## **Development Facilitation Team (DFT) – Review Comments**

**DRB Project No: PR-2020-003484 Date: 04/12/2023 Agenda Item: #1 Zone Atlas Page: E-10**

### **Application For: SD-2023-00048 – PRELIMINARY PLAT (DHO)**

DRB Project Number: 2020-003484 Hearing Date: **01-11-2023**  
 Project: Mojave Ridge Subdivision Agenda Item No: 1

CITY OF ALBUQUERQUE
 PUBLIC WORKS DEPARTMENT
 ENGINEERING DEVELOPMENT GROUP
MOJAVE SUBDIVISION
 GRADING AND DRAINAGE
 GRADING PLAN

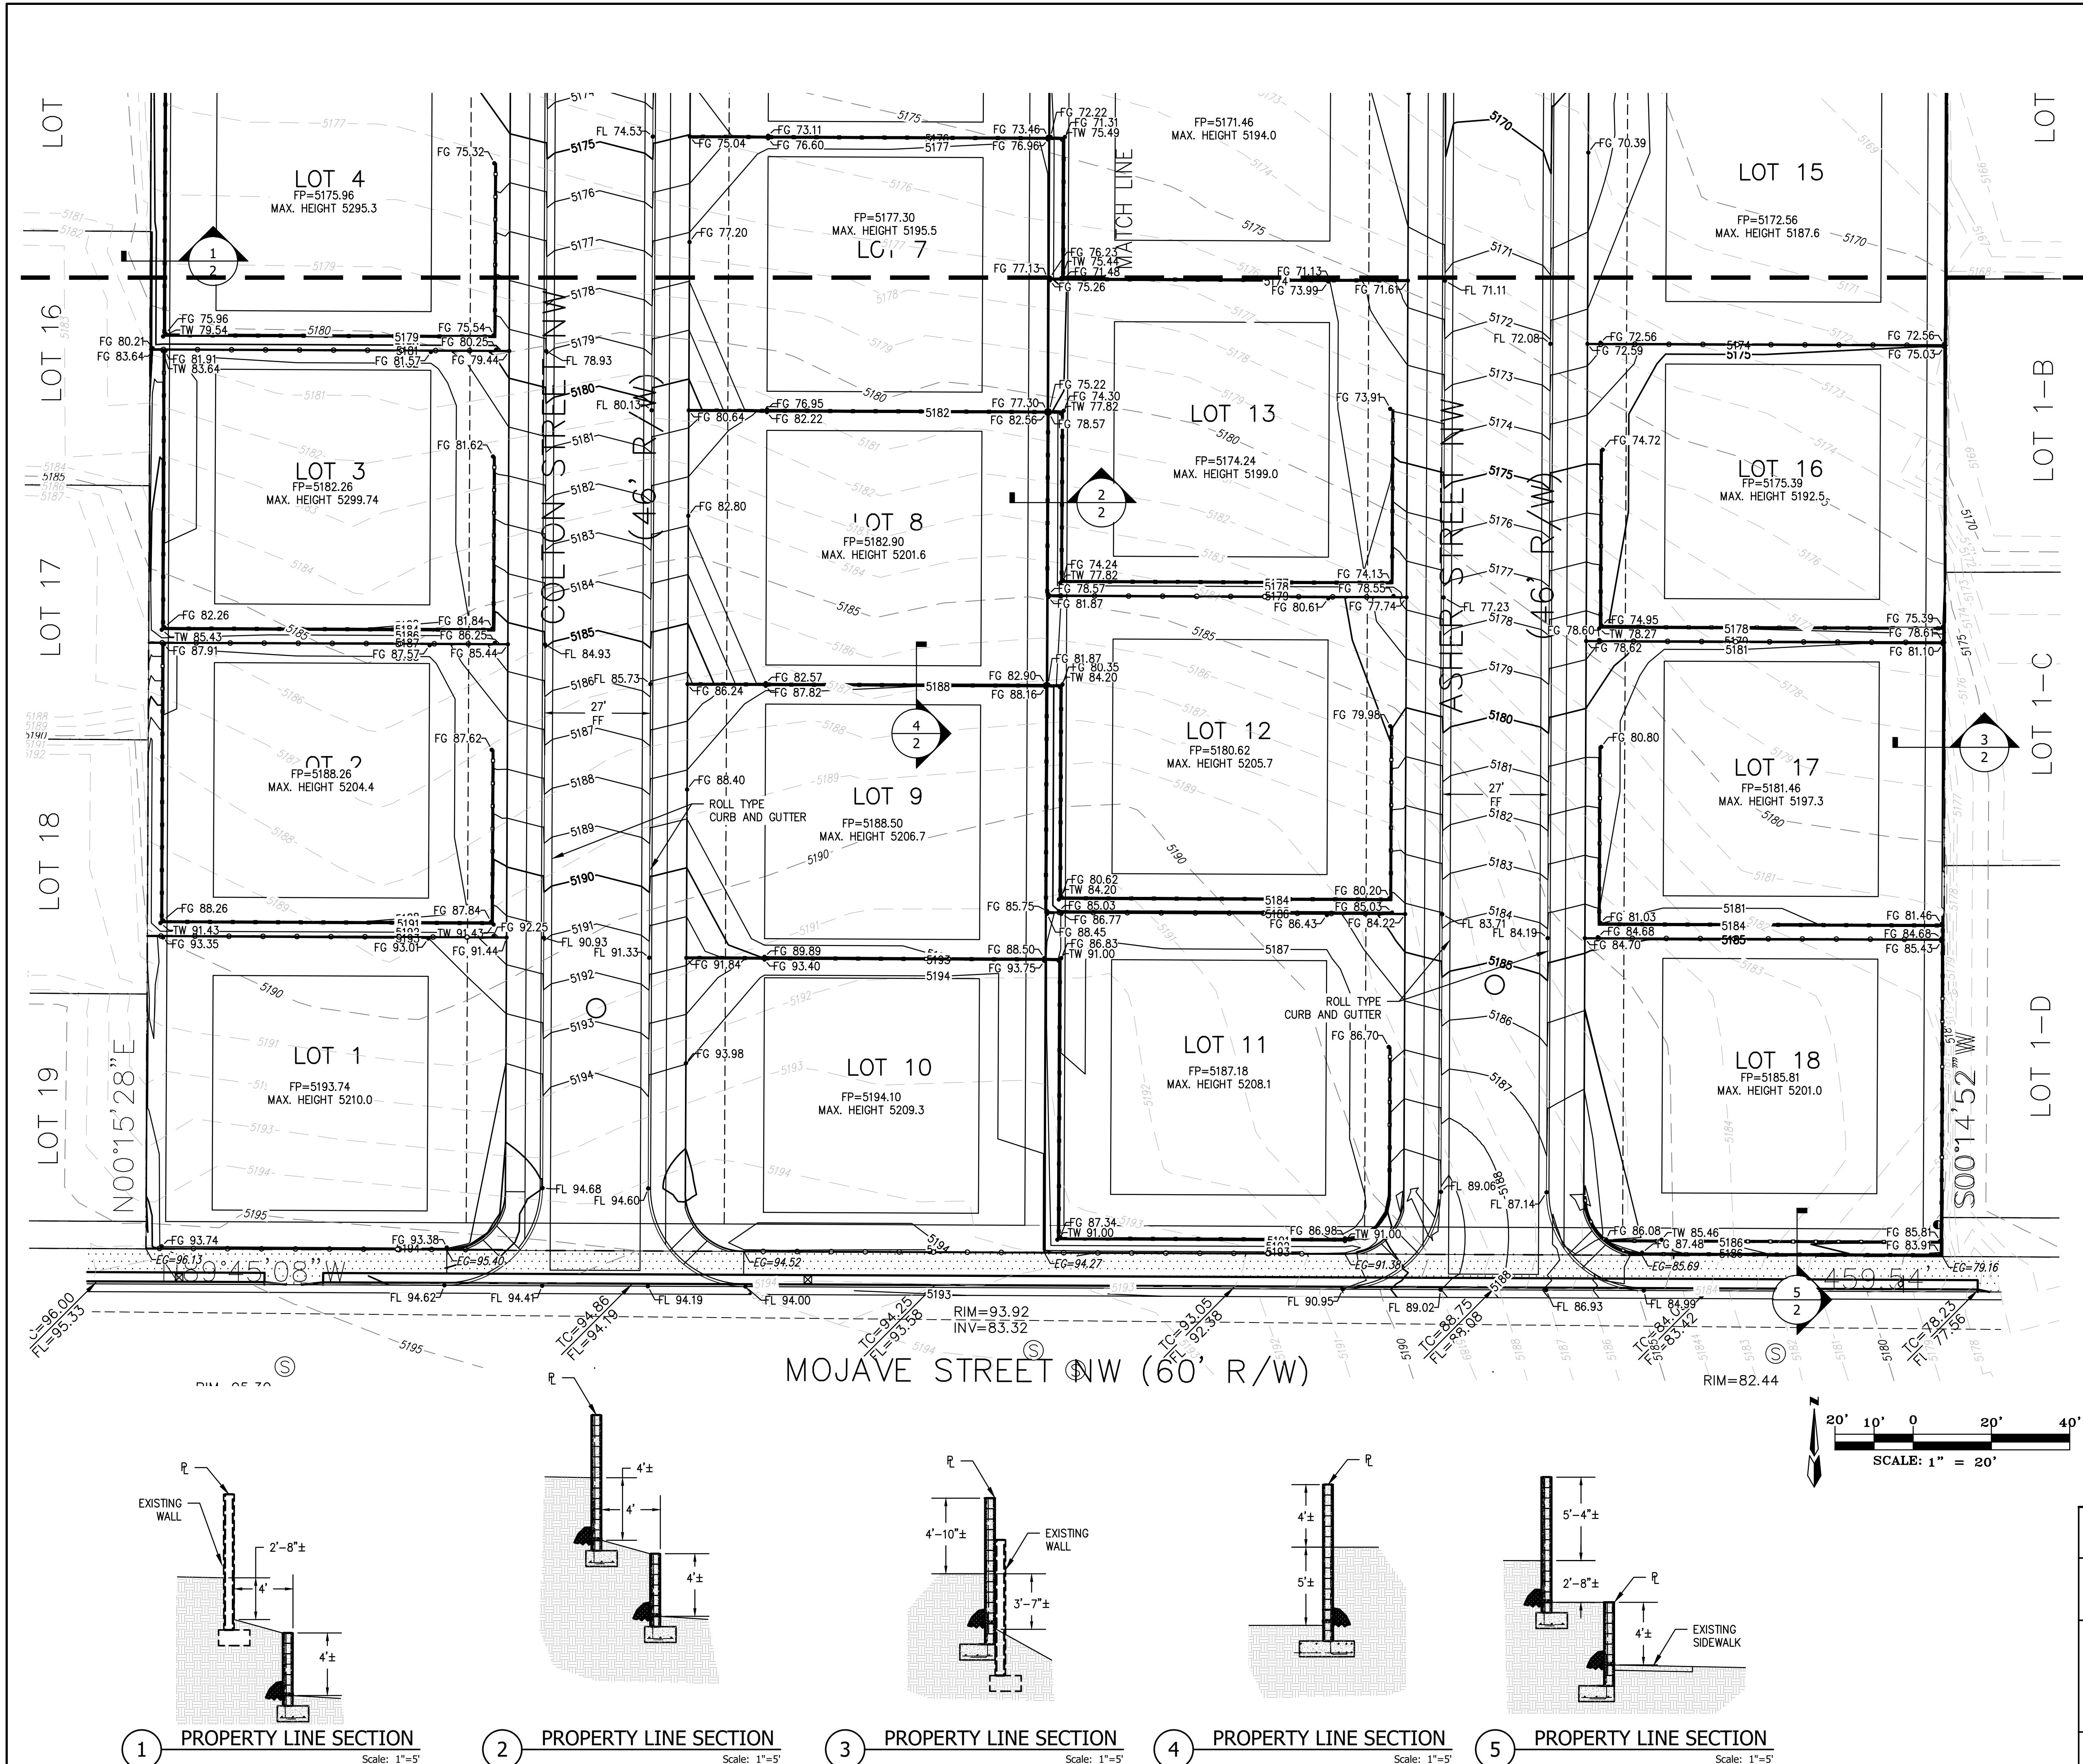
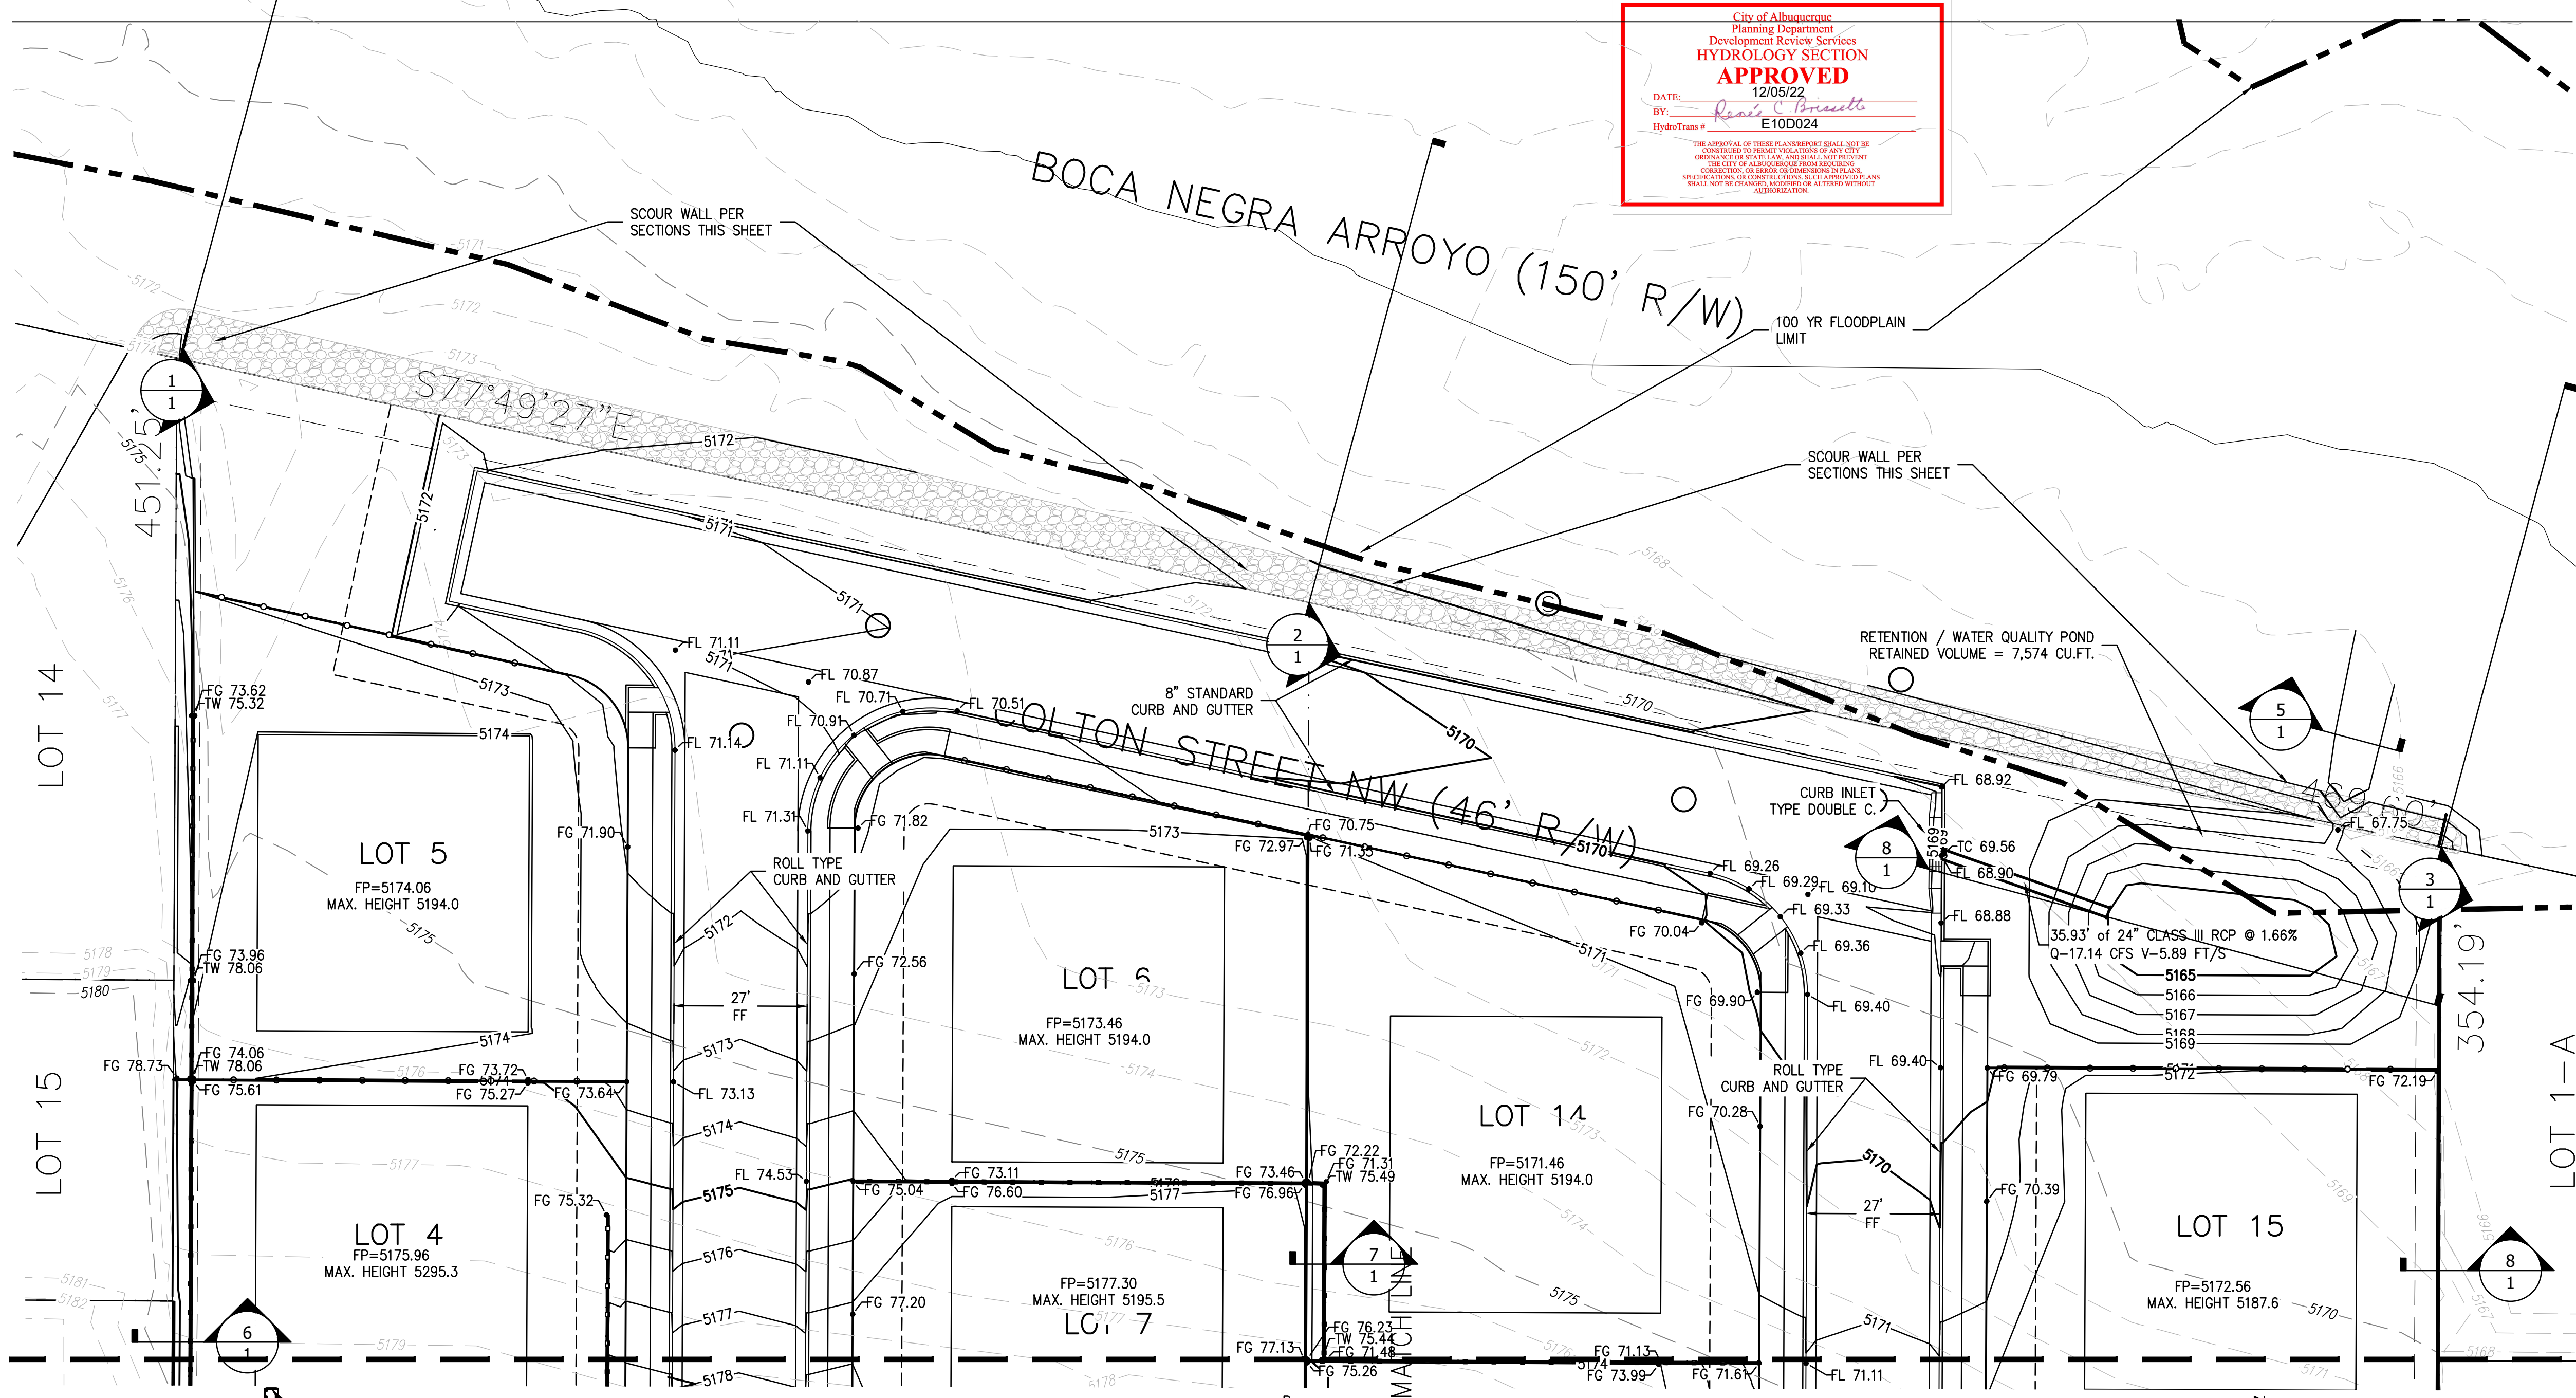
3. Pad sites on the Hydrology approved document must be corrected and limit the maximum height to 15 feet above natural grade as required in VPO-14-16-2 3-6(E)(3) Height restricted area

- **IDO 3-6(E) The parcels are in the VPO-2 Height Restricted Sub Area. Identify the allowable structure height vis a vis grading plan.** 'Building and/or structure height shall not exceed 15 feet, as measured from natural grade.'  
**\*Show height measurements from finished grade and natural grade. \*Clarify if standards are being met.**
